Application No: AB/114/20/PD
Site Address: Riverside House 2 Fitzalan Road Arundel BN18 9JS
Description of works: Notification for Prior Approval under Schedule 2 Part 1 Class AA for a additional 2 storeys on existing dwelling house.

Thank you for your internet representation made on 30th November 2020 which has been recorded as an objection with the comments as follows:

Drawing Title:
PROPOSED PLANS

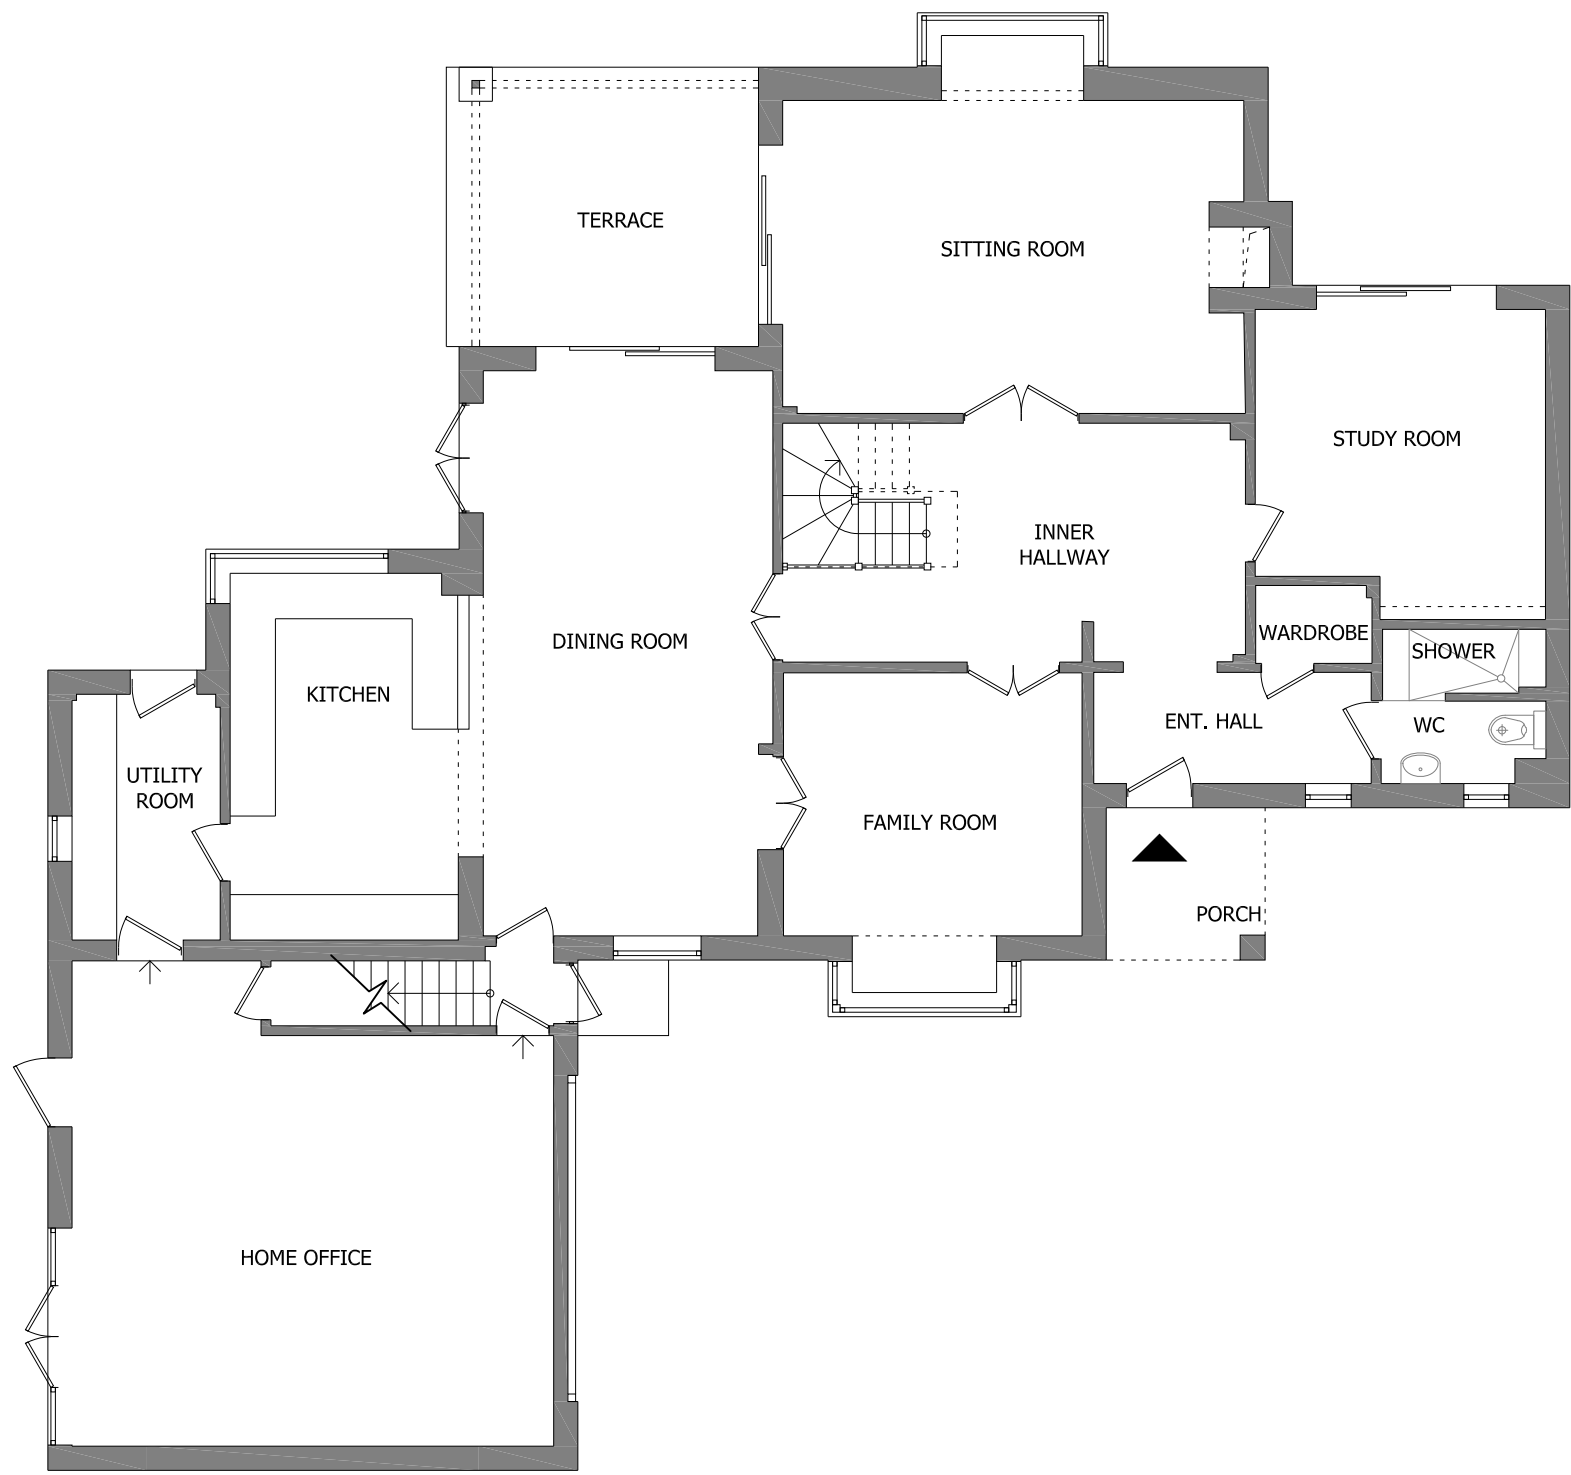
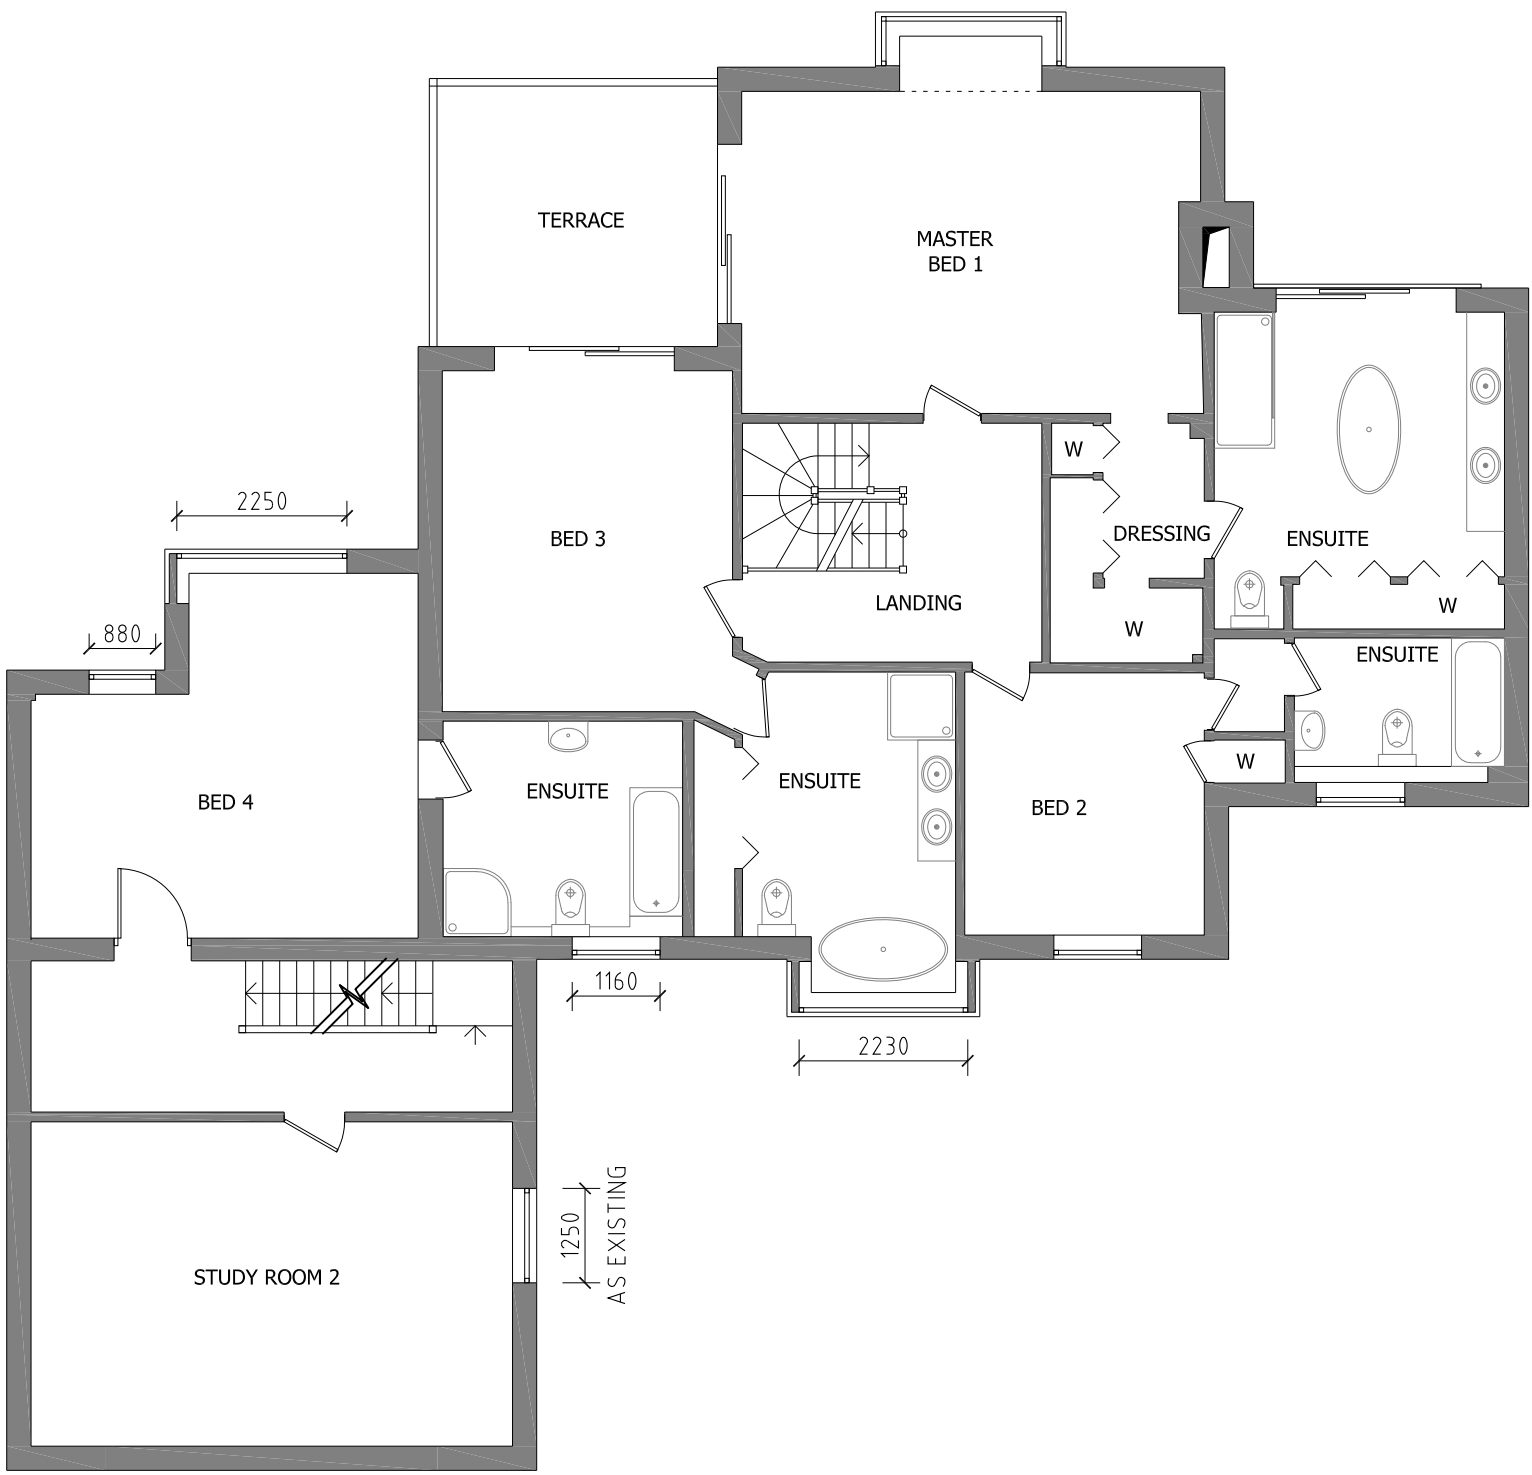
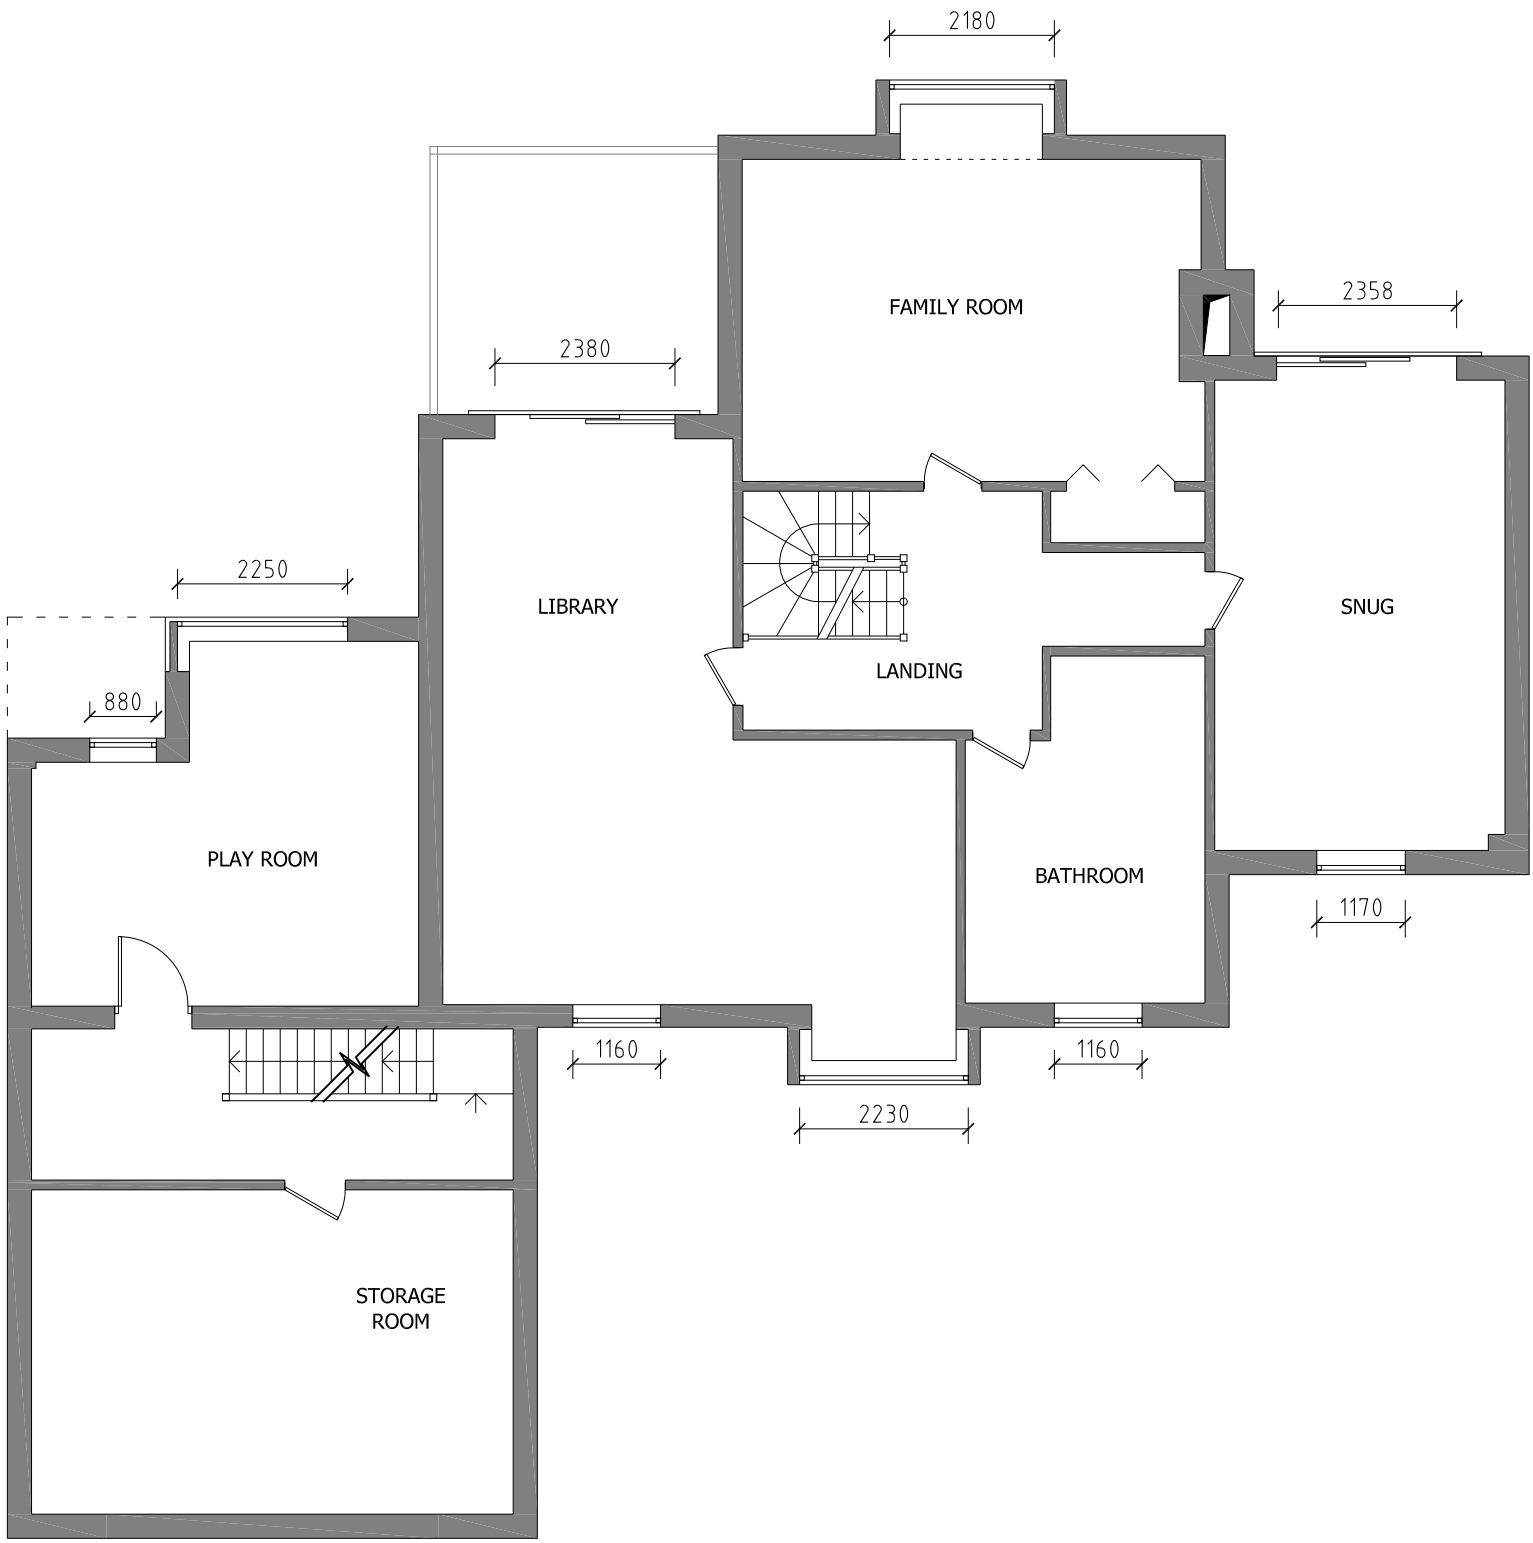
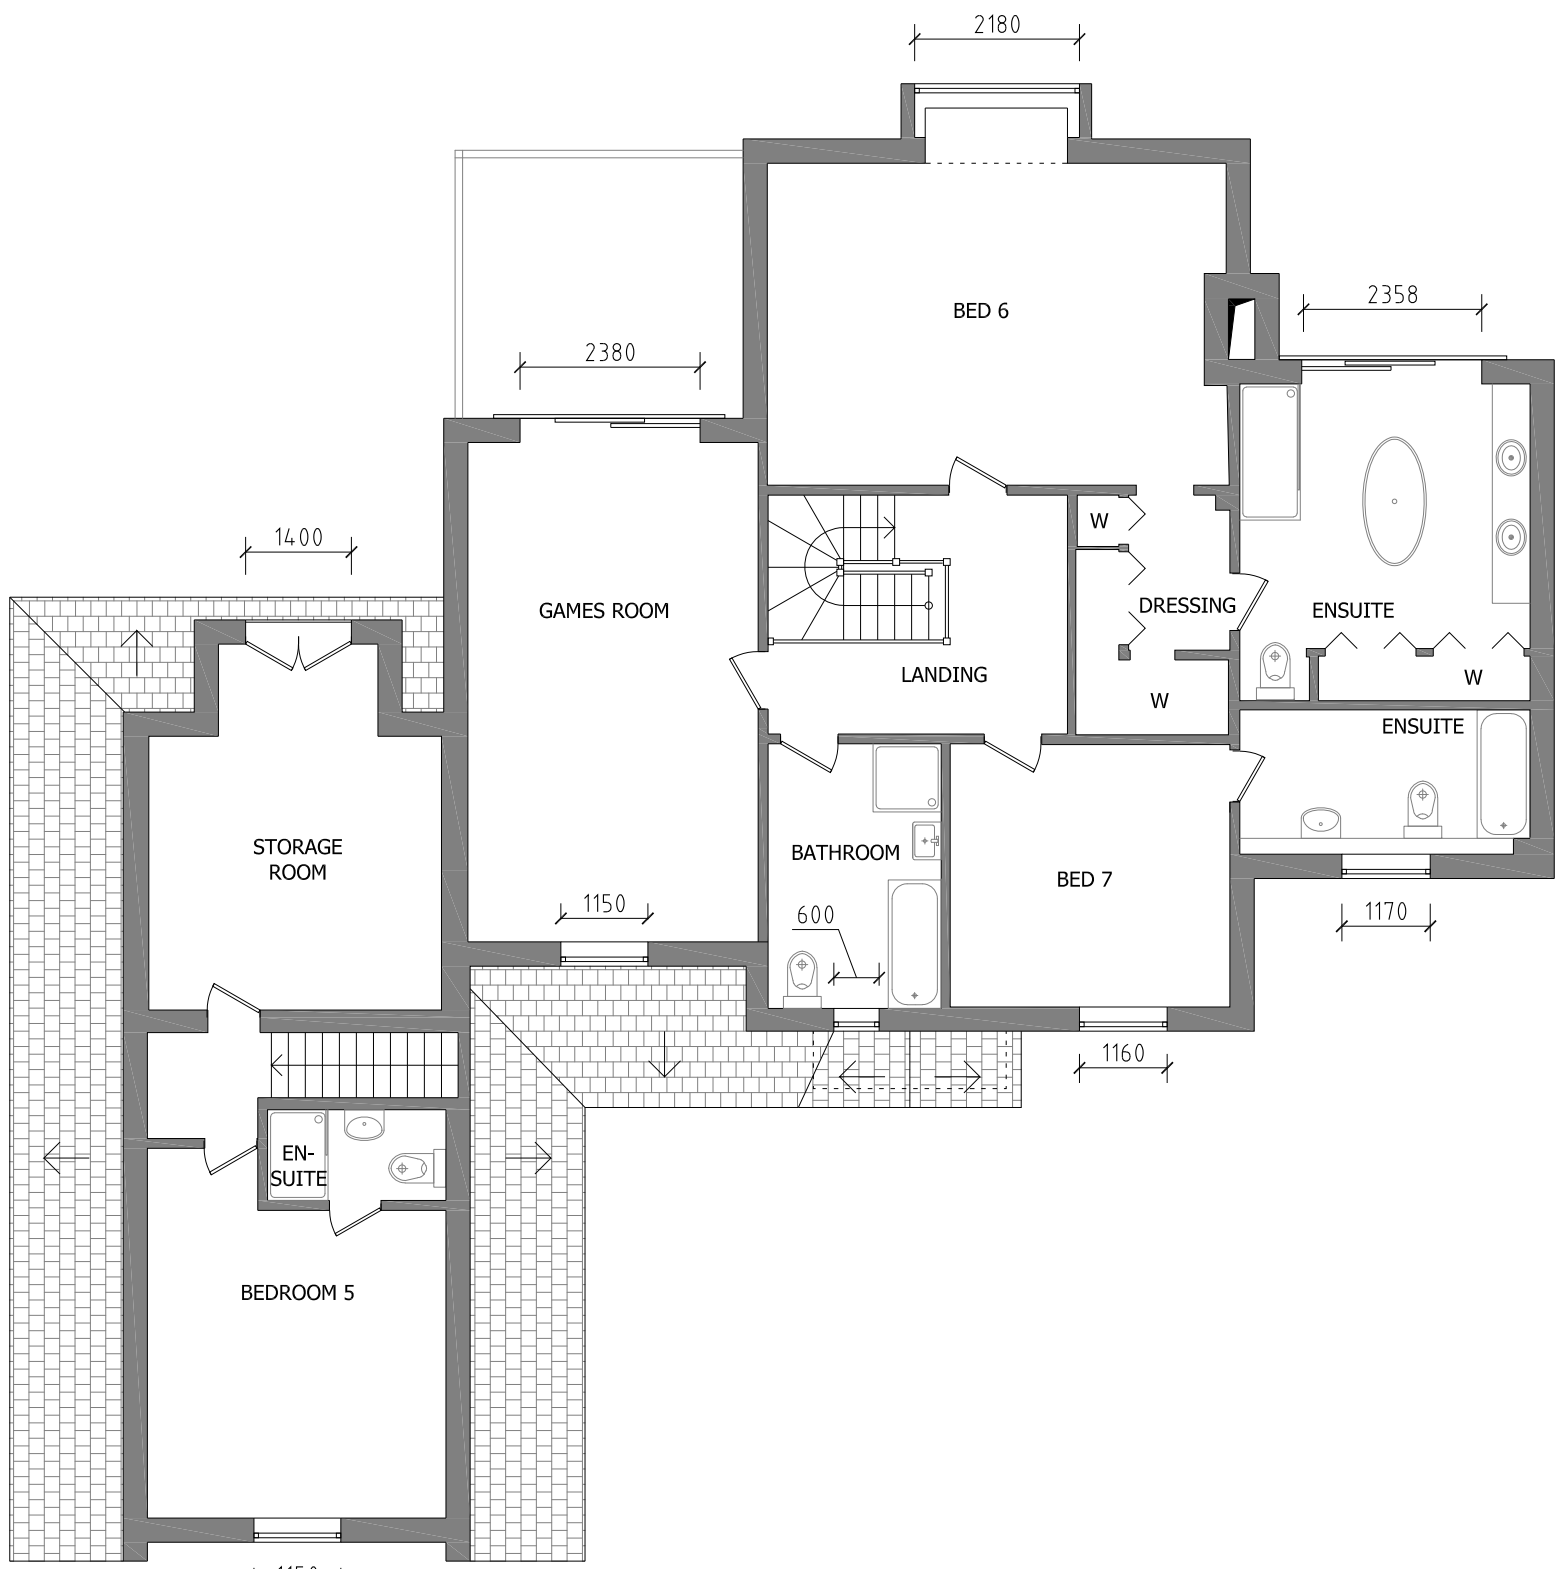
- suprisingly, it is planned for there to be eleven sanitary facilities, although one bathroom is shown as not fitted out;
- there eleven rooms designated for diverse activities e.g. snug, games room, library;

- there is no connection between the core of the house and the top three floors of the extension above the Home Office;
- the height of the extended dwelling will be disadvantageous to the Council's planned housing development of the Blastreat property and the blank wall of the south-eastern elevation of the Home Office and above situated close to the road is particularly insensitive;
